## Appeal Decision

**Appeal Ref: APP/A2525/W/16/3158148**

**Land rear of 50 Station Road, Long Sutton, Spalding PE12 9BP**

- The appeal is made under section 78 of the Town and Country Planning Act 1990 against a refusal to grant outline planning permission.
  - The appeal is made by Mr Stefan Brazzo against the decision of South Holland District Council.
  - The application Ref H11-0512-16, dated 26 May 2016, was refused by notice dated 18 August 2016.
  - The development proposed is the erection of a new dwelling.
-

PROPOSED DWELLING REAR OF 50 STATION ROAD LONG SUTTON	
A3 @ SCALE SHOWN	
DRG: PLO1	
MR S BRAZZO

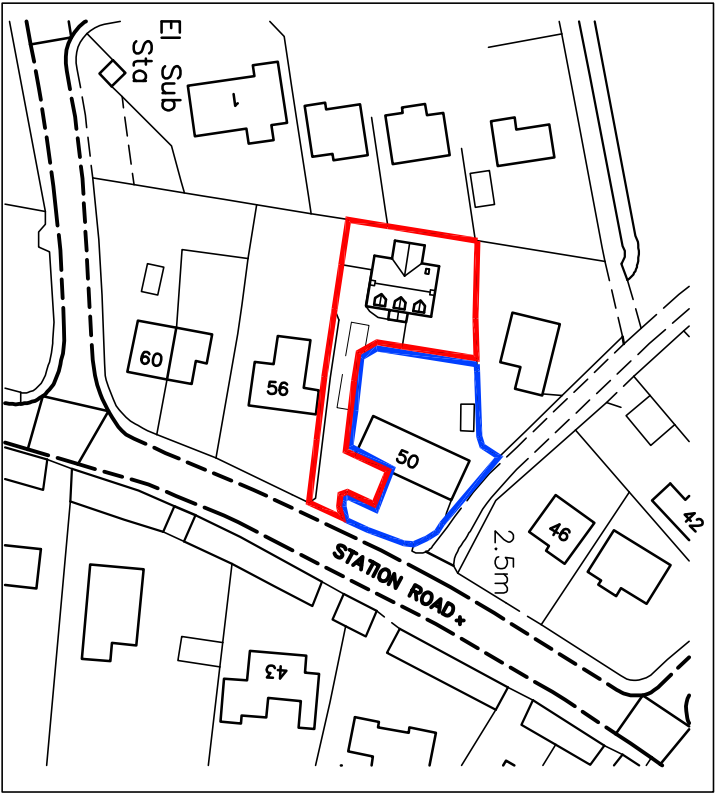
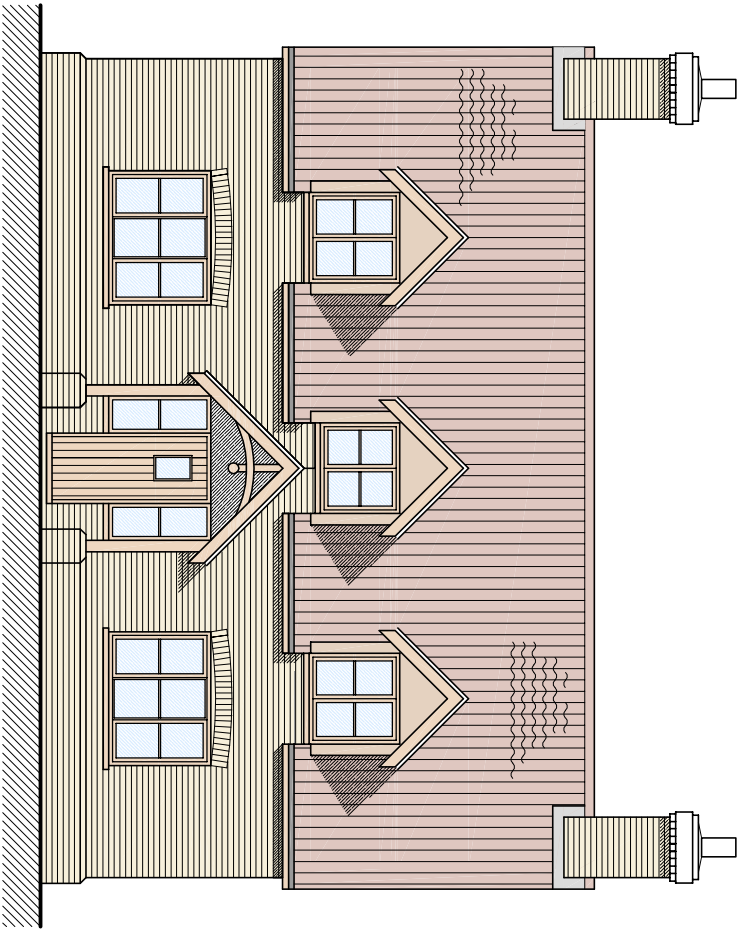
6. An illustrative layout shows a 'T' plan 1½ storey dwelling on the site, with dormers towards the front of the property and the rear of No 50. The garage would be removed to allow for access. Evidence states that second floor windows would be avoided in the rear of the property to avoid overlooking of No 3. This drawing shows that the dwelling could sit in the middle of the plot, with the rear of the back gable close to the boundary fence with No 3.

9. At present there is a reasonably high close boarded fence on the boundary between No 50 and No 3. The illustrative plan states that a new one would be erected. However, of a standard 1.8m fence approximately 1m would be effectively negated by the required FFL of the dwelling, and consequently rearward facing ground floor windows would have the potential to look at least partially over such a fence towards No 3.

10. Due to the size of the plot and the proximity of both No 50 and No 3, there would be limited options for the siting of any 1½ storey dwelling in reserved matters. Not only would this create issues in terms of overlooking of No 3 when considered the required FFL levels, this would also have the effect of making the proposed property conspicuous in the local area, being clearly visible from Delph Road to the south. Whilst there are a range of dwelling types and sizes in the area, and previous backland development in terms of cul-de-sacs, the proposal would introduce a new form of development into the area in the form of back garden development. Due to the above I am not convinced by the evidence provided that the plot could accommodate such a development without appearing cramped and incongruous within the area.
